Our ref: Nepean Hospital Redevelopment Project - Stage 2 (SSD-16928008)

Subject: Request for Additional Information

Detail Plan - Upper Terraces Level 6

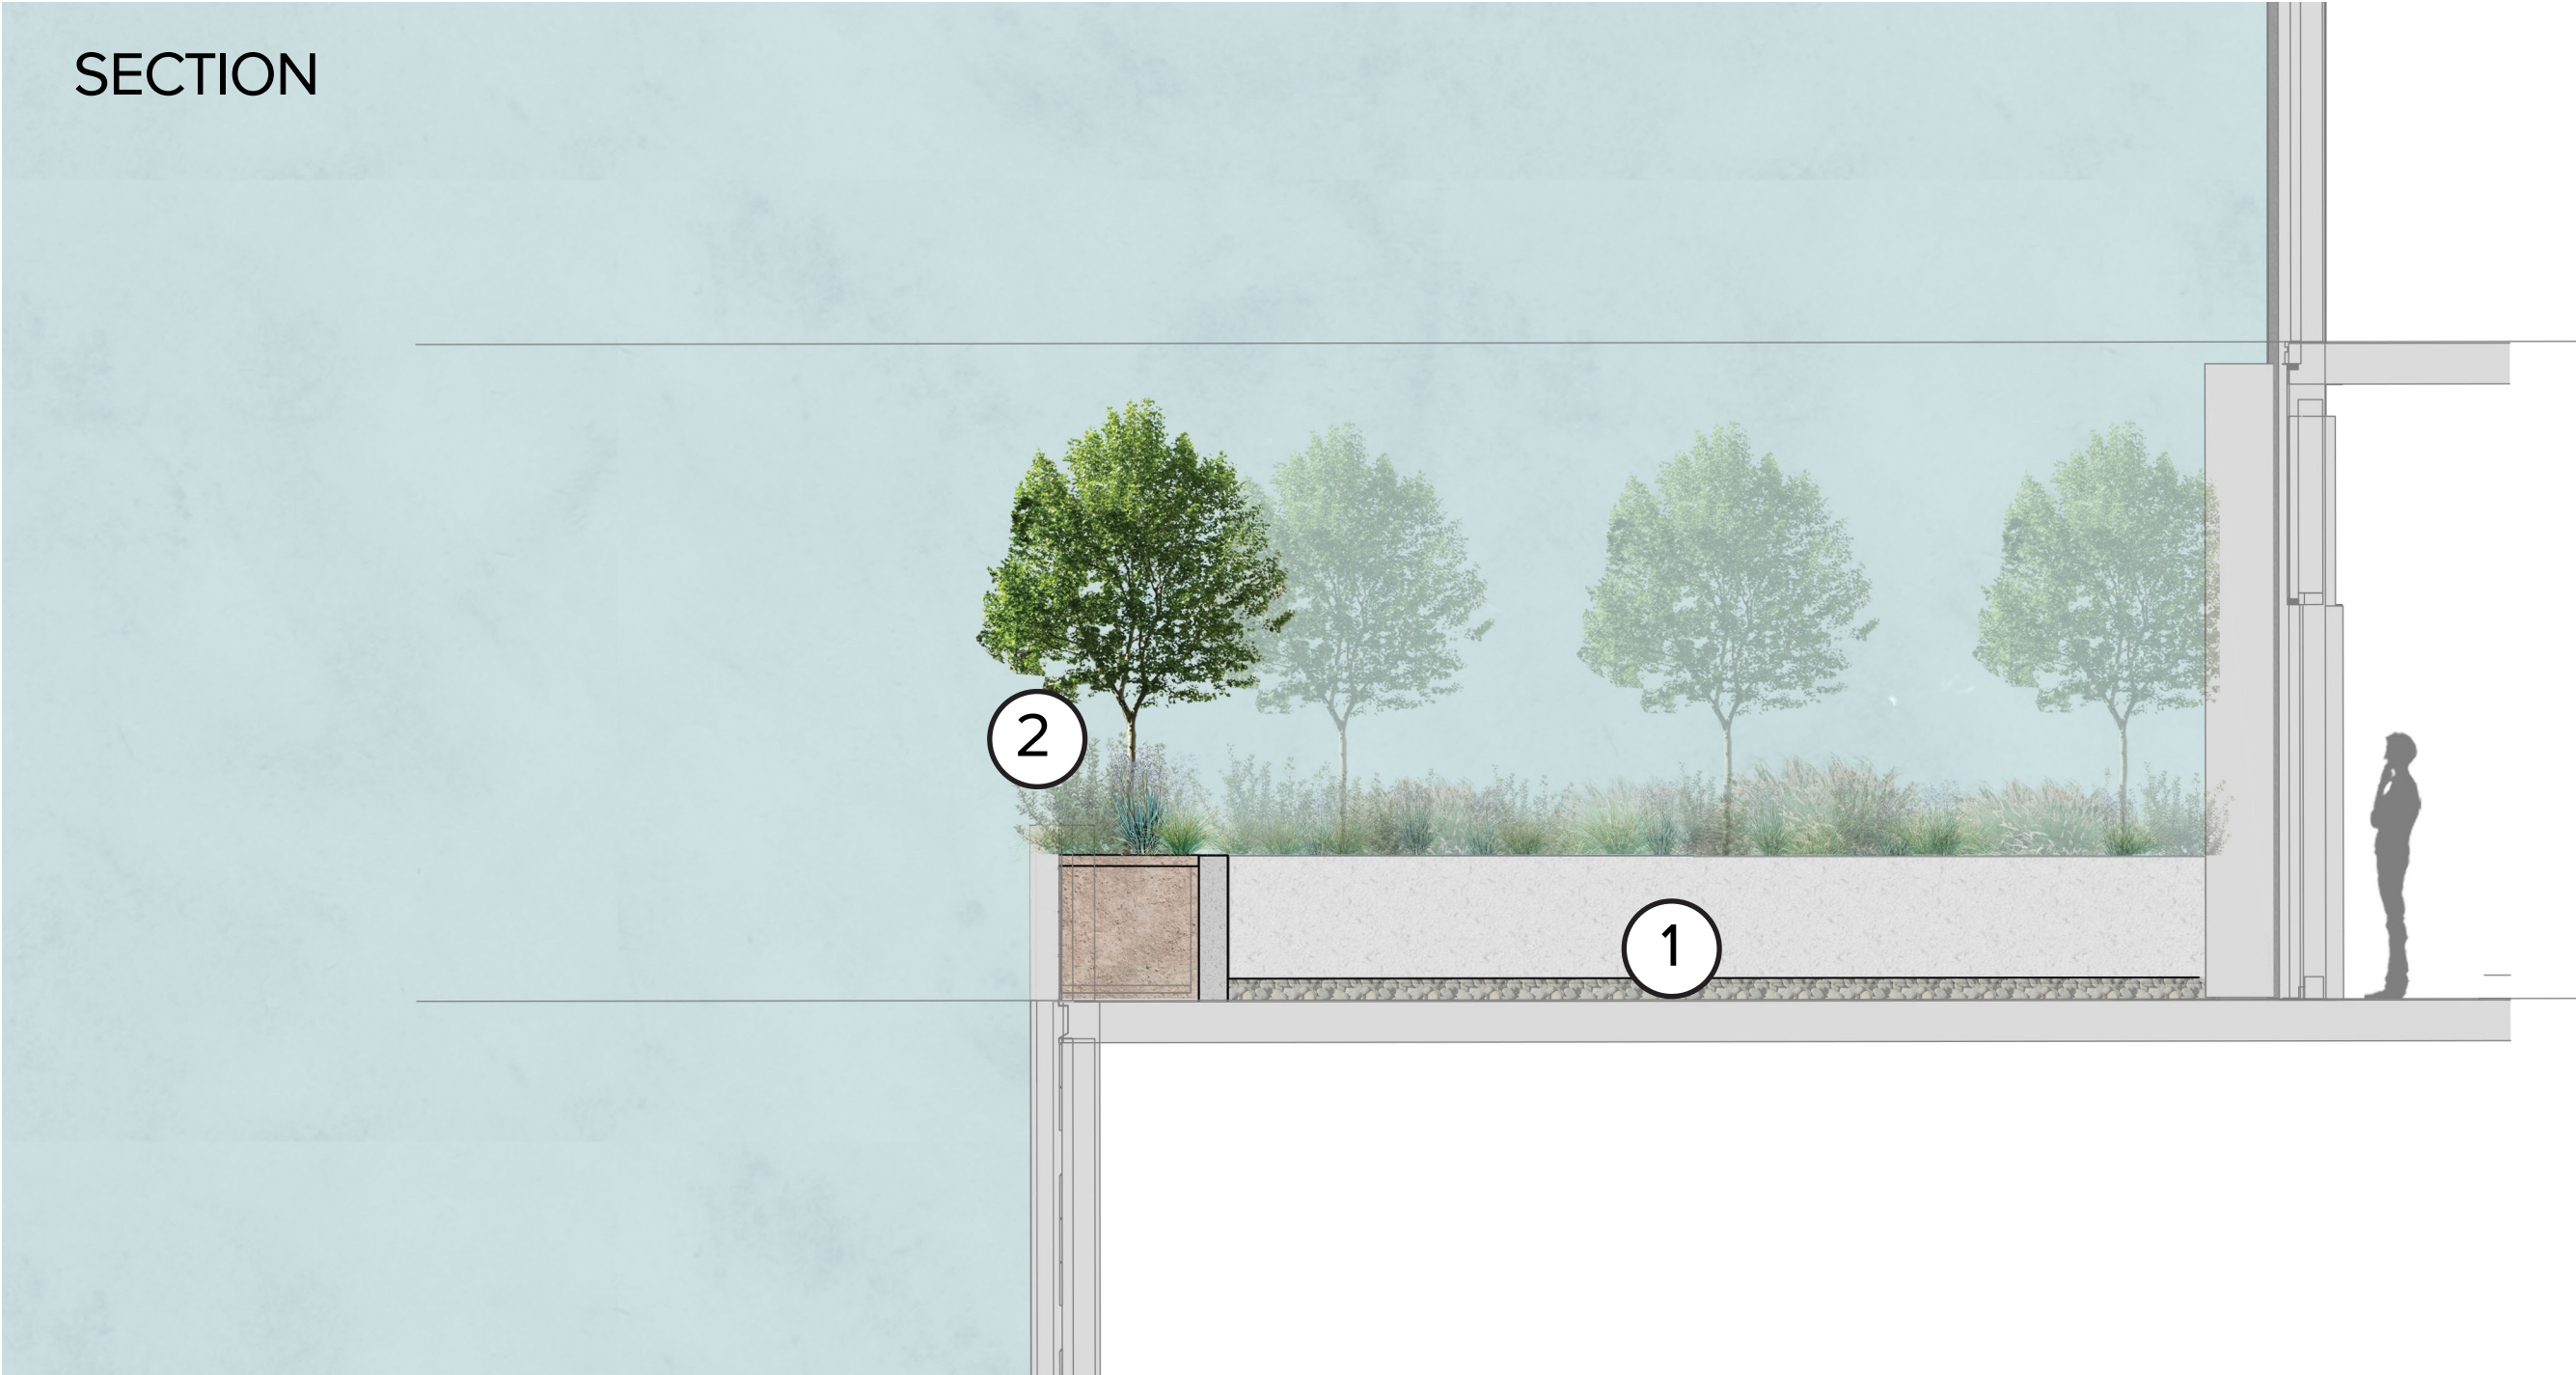
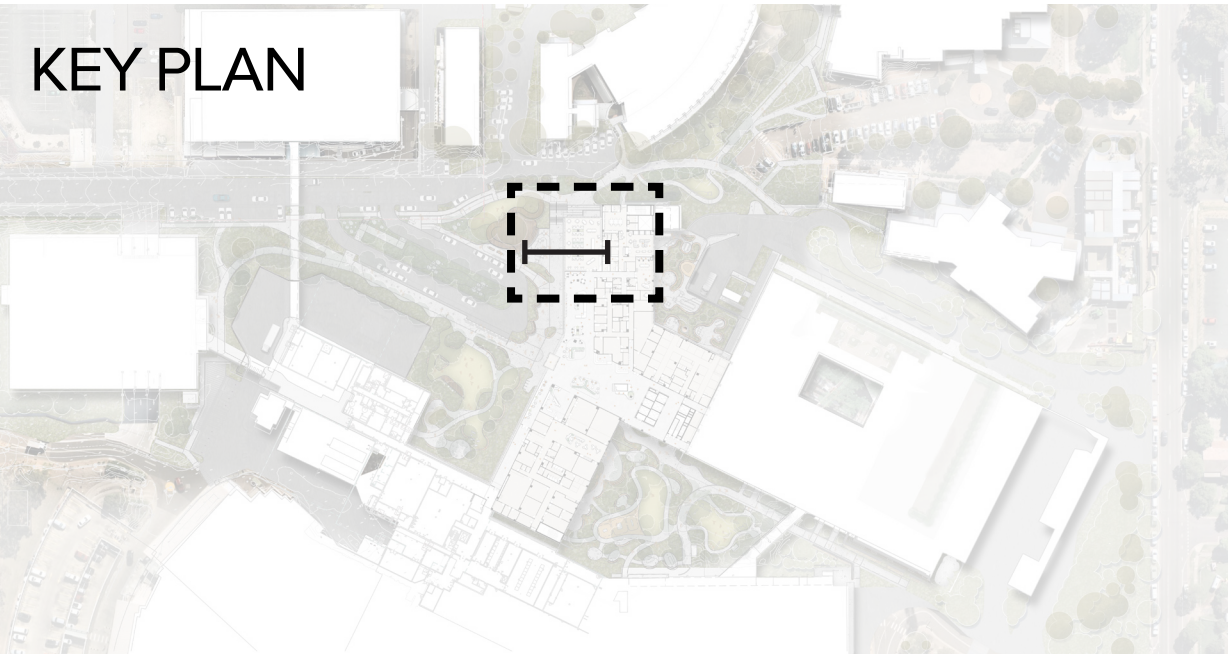
- evidence is to be provided to demonstrate deep soil is sufficient to support the proposed planting.
- consideration should be given to providing a useable outdoor area on the north-western terrace located on Level 6 of the proposed building.
